Planning Applications, Ribble Valley District

3/09/0116 78 Waterloo Road, Clitheroe

PROPOSED GROUND FLOOR LAYOUT

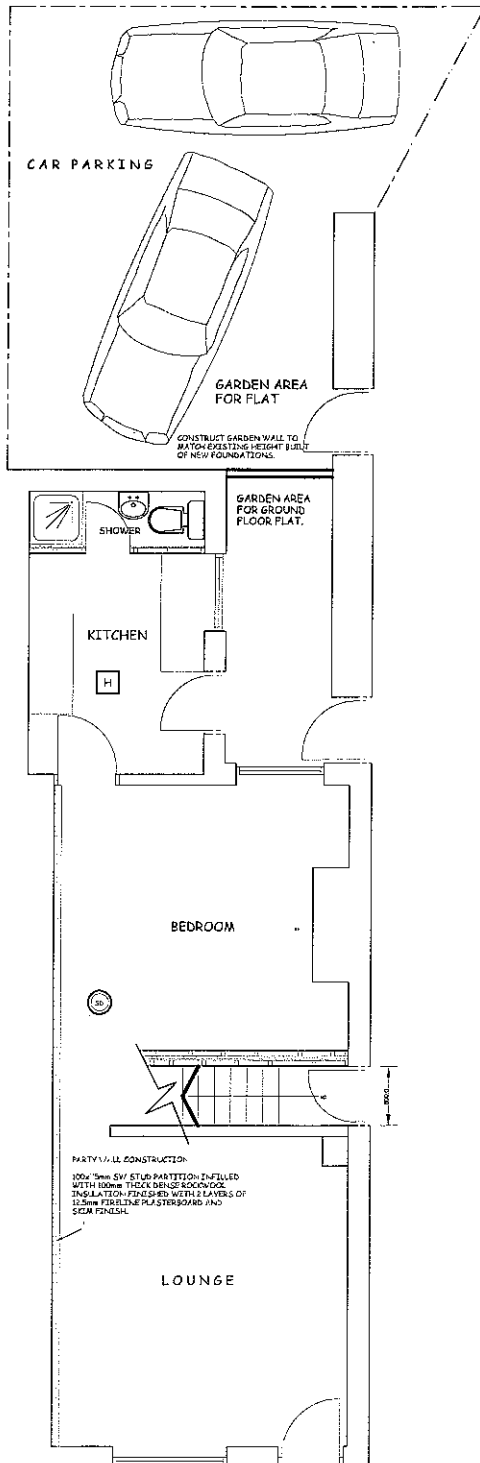
However, the parking arrangements at this address are poor and a vehicle reversing from the site will have very restricted visibility along the footway fronting 1 Brook Street. This could be improved slightly by lowering the sidewall to not more than 1m high and easing the access away from the gable of No.1 by the provision of bollards or other agreed means

It might be difficult to insist on these changes bearing in mind the existing use but at least a condition requiring the provision of parking in accordance with a scheme to be agreed and its future retention would be beneficial. I would also suggest that the applicant considers the provision of an H-bar marking to reduce the risk of other vehicles obstructing the site access.
